Re: Part 3A Project Application – Summer Hill Flour Mills (MP10_0180)

Subject: Exhibition of Project Application for Stage 1 of the former Allied Mills Flour Mill Redevelopment, 2-32 Smith Street, Summer Hill (MP 10_0180)

Attachment 2: Response to Assessment Issues

Pre Adaptation Plan

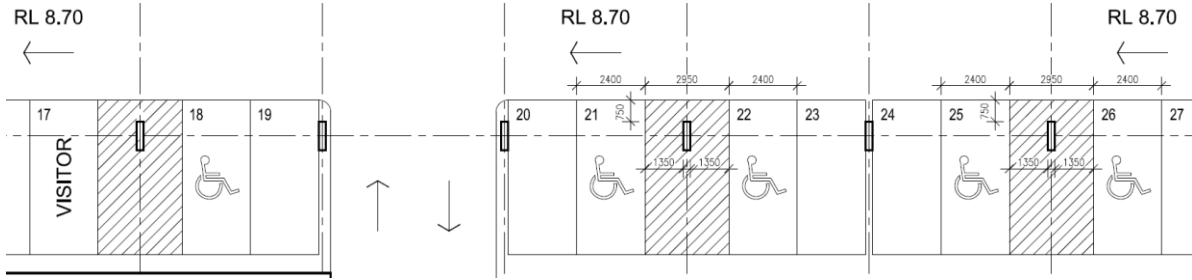
The Department acknowledges the Proponent's Accessibility Report and confirms it's in principle support of its conclusions. The Proponent is required however to clearly nominate the proposed adaptable units on the plans and provide pre- and post-adapted plans for all units, particularly if the layouts differ amongst the units.

The table at drawing DA-700 of Attachment 1 of the EA, lodged with the Department, identified the adaptable dwellings as:

- 4A 3.2;
- 4A 2.2;
- 4A 1.2: and
- 4A G.2.

The pre and post adaptation layouts of these apartments is shown on drawing DA-119 of the architectural package at Attachment 1 of the EA lodged. The four (4) dwellings, identified as adaptable, are of a single type and are readily adaptable.
